Arun District Council
Arun Civic Centre
Maltravers Road
Littlehampton
West Sussex BN17 5LF
Planning & Building Control General Enquiries
Tel: (01903) 737756 Fax: (01903) 730442
Dx: 57406 Littlehampton
Minicom: 01903 732765
e-mail: planning@arun.gov.uk
website: www.arun.gov.uk/planning

Town & Country Planning Act 1990 (as amended)
Town & Country Planning (General Permitted Development) Order 2015 Schedule 2, Part 16

Application No: AL/96/21/TEL
Site Address: Corner Westergate Street and Meadow Way Aldingbourne PO20 3QT
Description of works: Prior notification under Schedule 2, Part 16, Class A for H3G phase 8 15 m high street pole c/w wrap around cabinet & 3 further additional equipment cabinets.

265 PROPOSED SITE ELEVATION

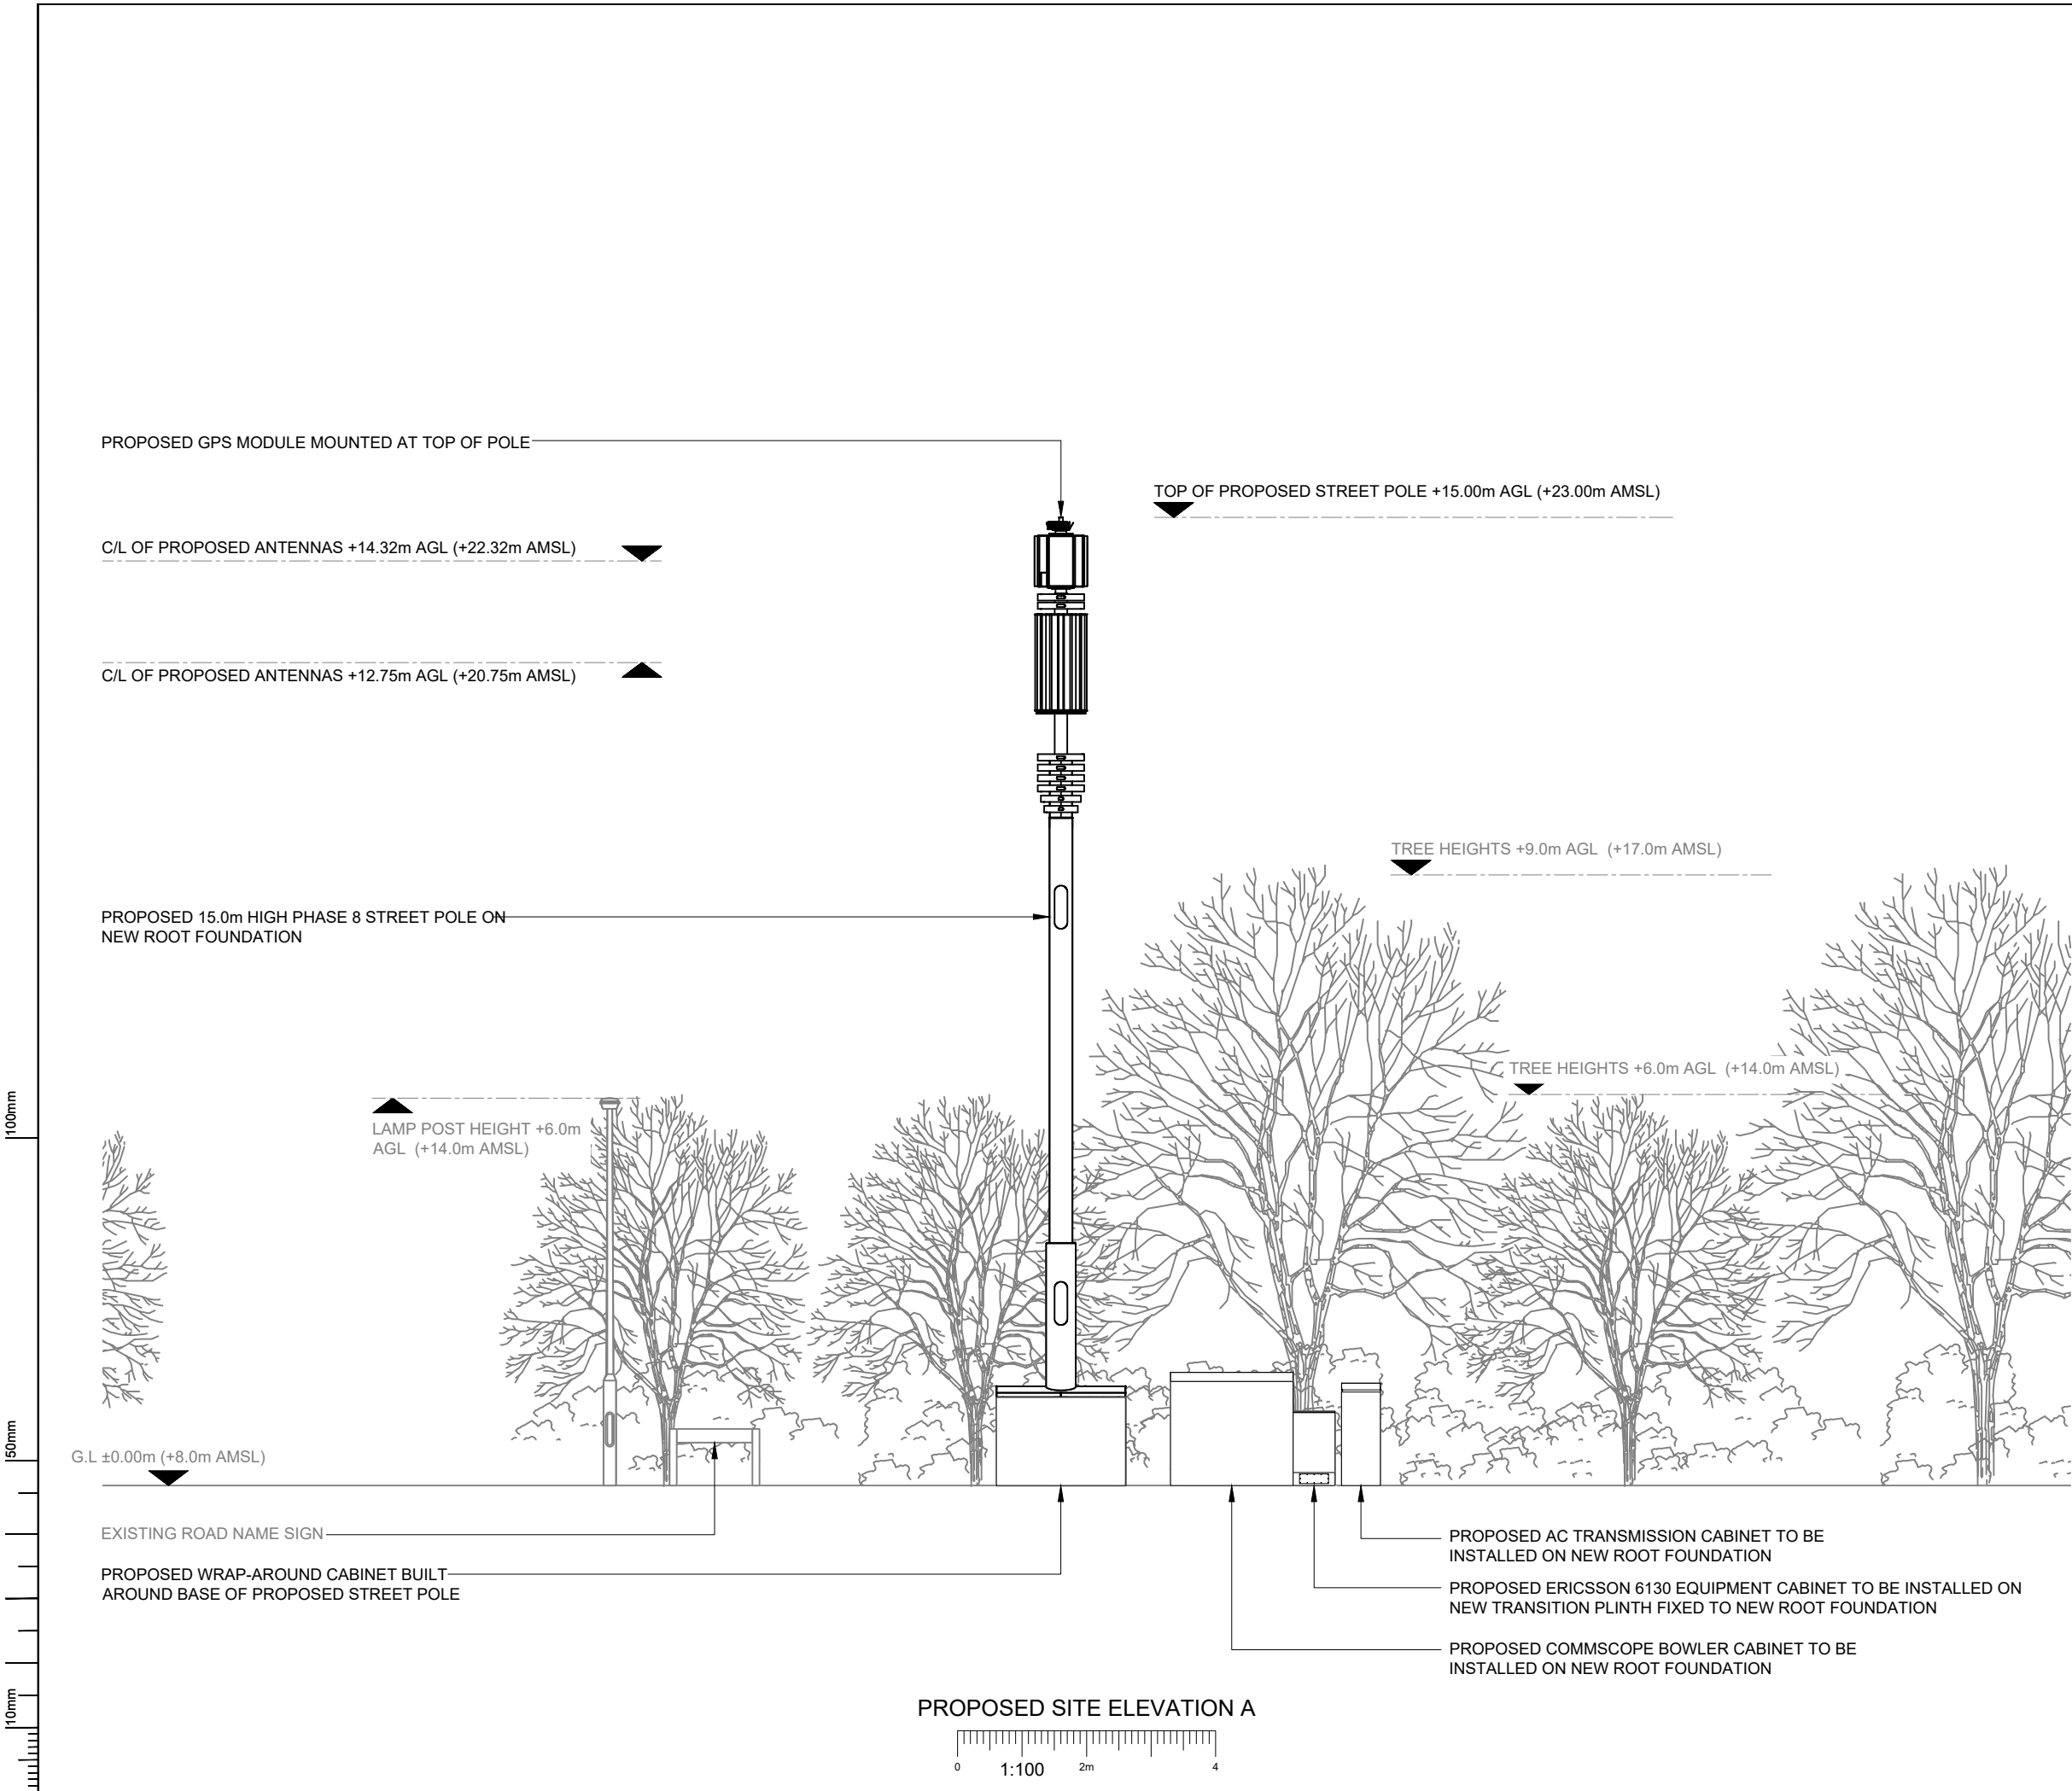
OBJECTION - The description of the application is incorrect on advertised notices as the pole will be 15m high, not 1.5m. The application therefore needs to be withdrawn, and resubmitted and re-advertised. (This mistake has been drawn to the attention of Amber Willard).

The pole is out of keeping in a residential area, and will dominate the street scene, contravening ANDP Policy H9, and it is felt that a less obtrusive location could be sought. The Council also feels that there has not been any effort to minimise the impact by the addition of screening or soft landscaping.
